Development Control
Ribbles Valley Borough Council

Your ref: 24.0990
Our ref: D3.24.0990
Date: 6th January 2024

Address: Barrowbridge House Club Street Barrow BB7 9AY

Proposal: Technical details following permission in principle application (3/2023/0989) for residential development comprising 4 dwellings.

Plot 3 and 4 Garage Floor Plan

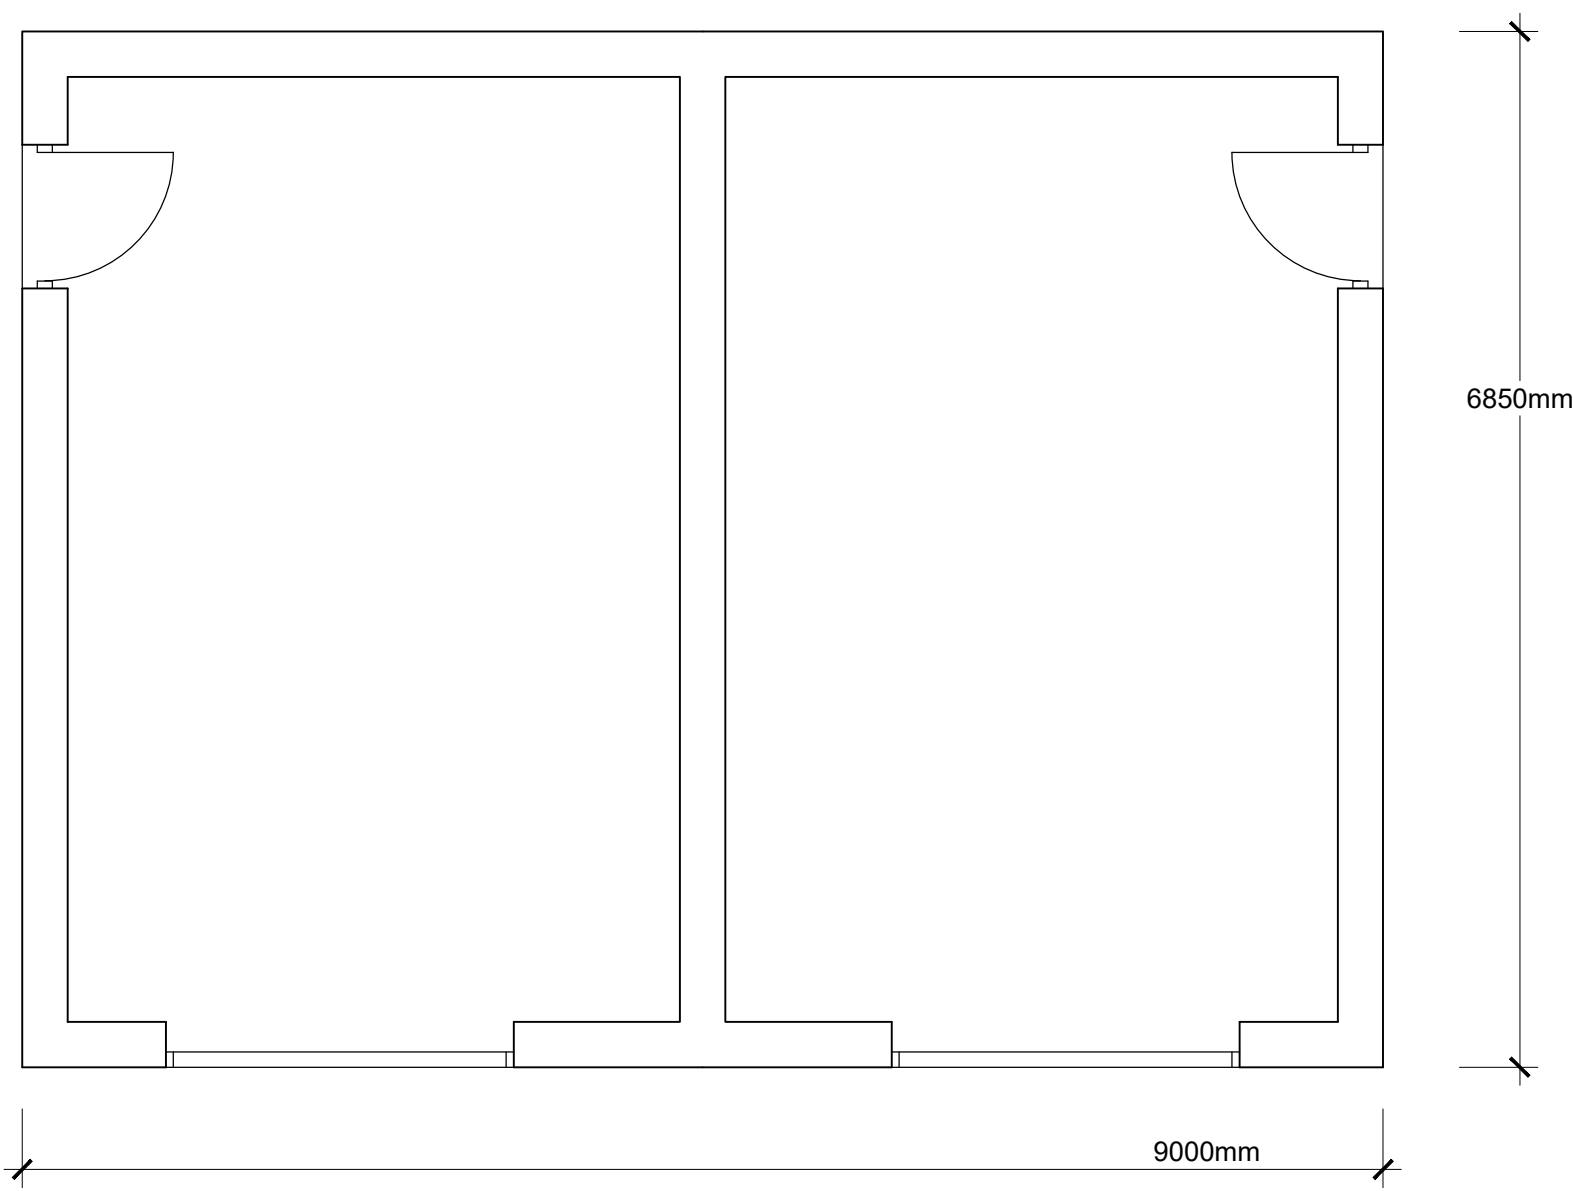
Plots 3 and 4 have detached single garages measuring 4m by 6.4m internally which is sufficient to count as a car parking space and secure cycle parking (3m by 6m). The distance between the garages and the access road is 4.8m long which will likely result in an overhang of the vehicle onto the access road and should be extended to 6m, or 5.5m if a roller shutter door is fitted to the garage, rather than up and over.

Lancashire County Council acting as the Highway Authority would request further information relating to the refuse collection and a swept path analysis for the largest service/emergency vehicle. An amendment to the garage layout at plots 3 and 4 is requested.

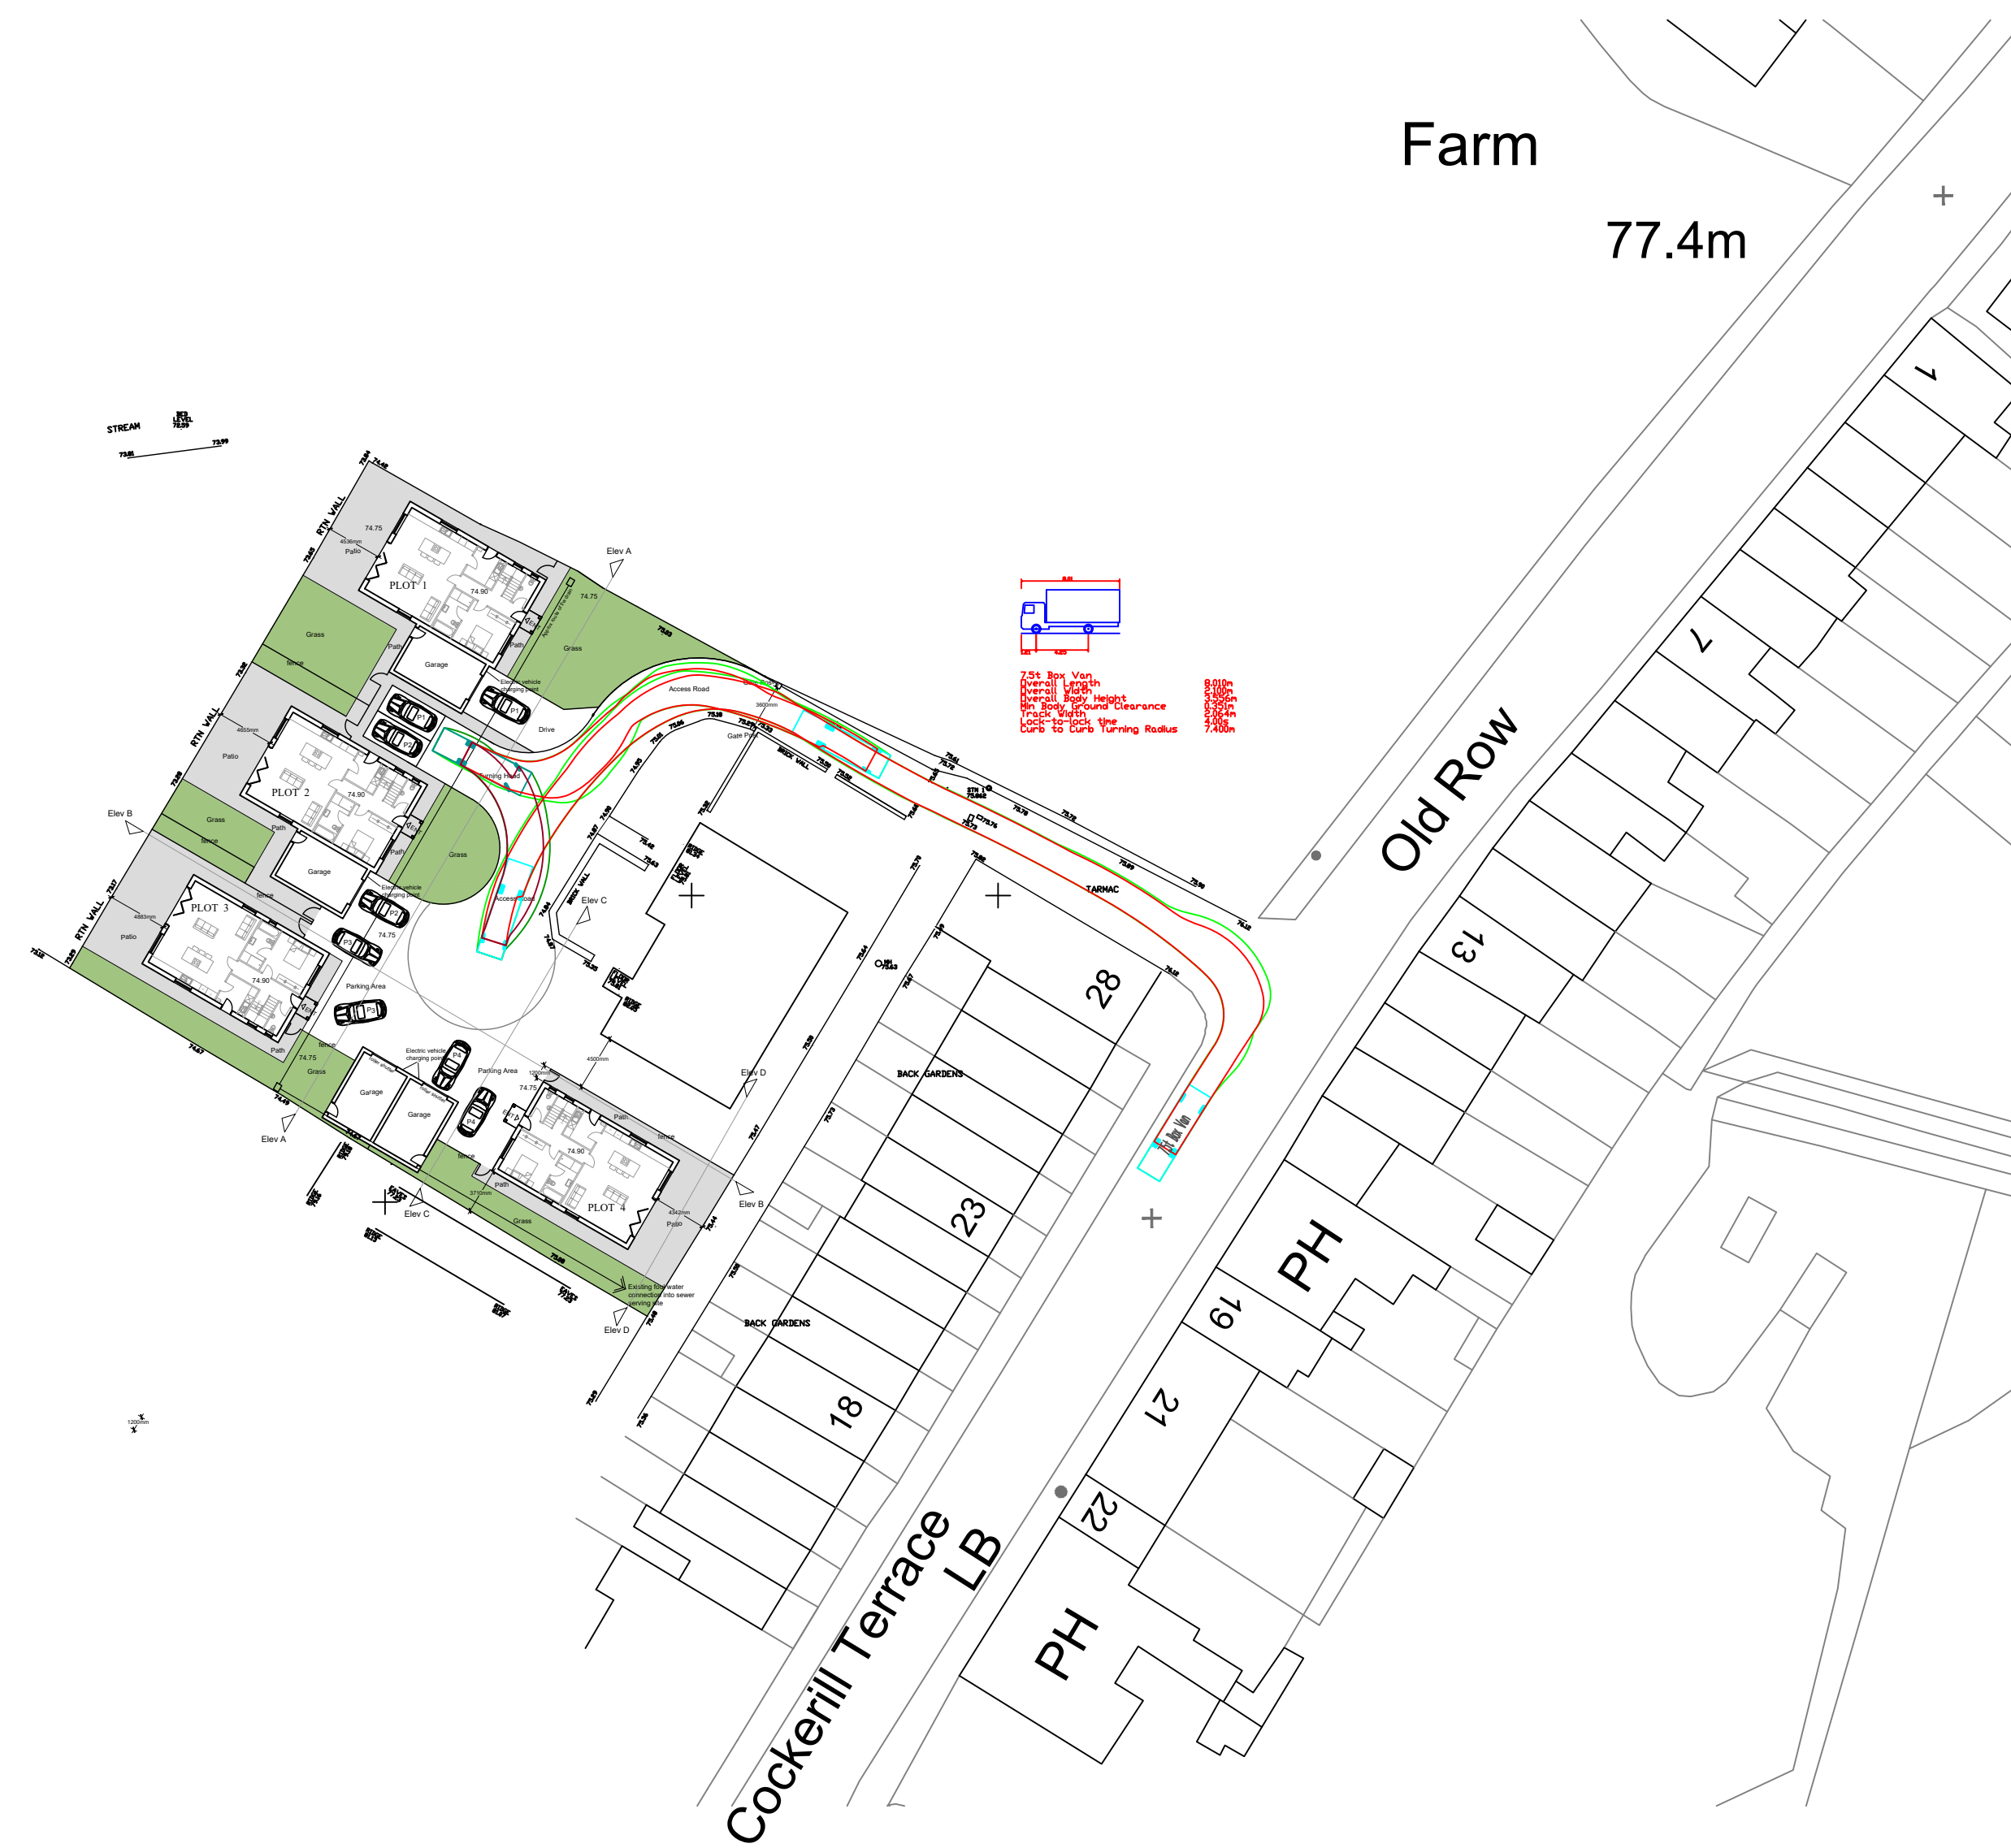
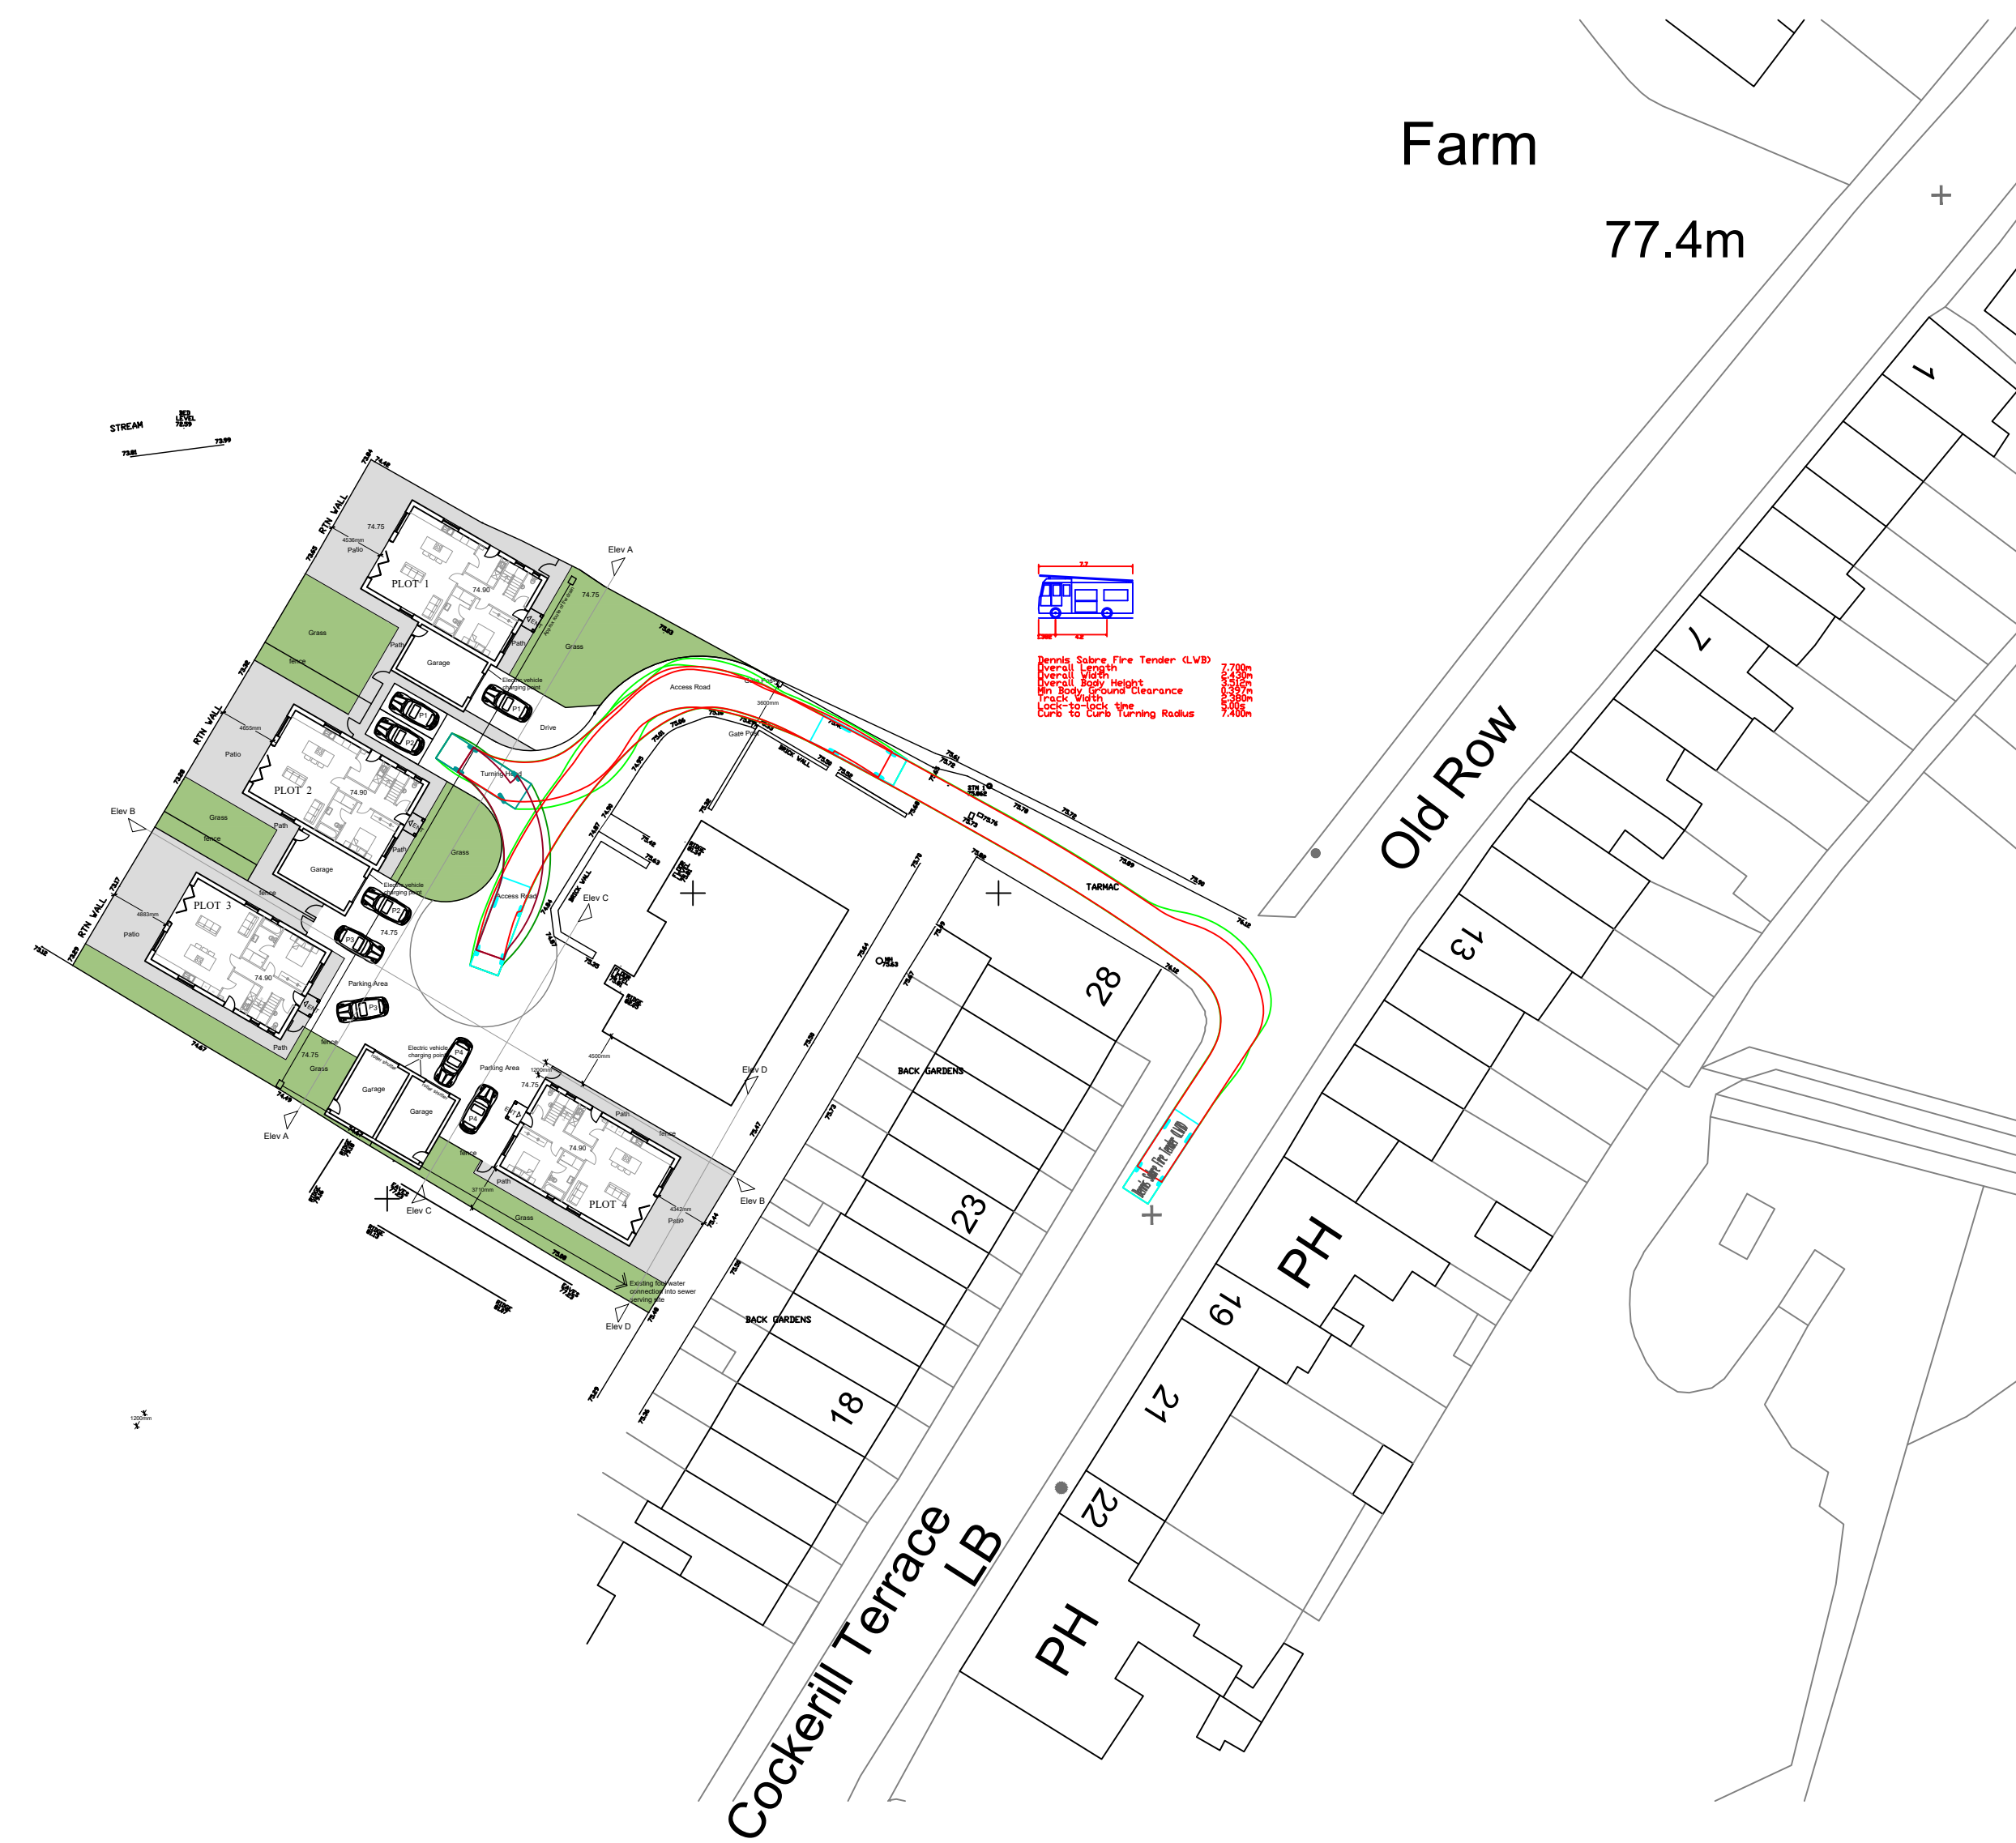
A swept path analysis for a refuse, delivery and/or emergency vehicle, whichever is the largest expected should be submitted to ensure that large vehicles can enter and exit Whalley Road in forward gear. The submitted layout appears unsuitable to accommodate an 11m long refuse vehicle however the applicant should contact Ribble Valley Waste Team to confirm if they will enter the site to collect waste or if it will be collected from an alternative location. In either case additional information is requested to be submitted before the decision. The maximum distances of 30m for residents to move their waste receptacles and 25m for operatives to collect waste should be designed into the scheme.
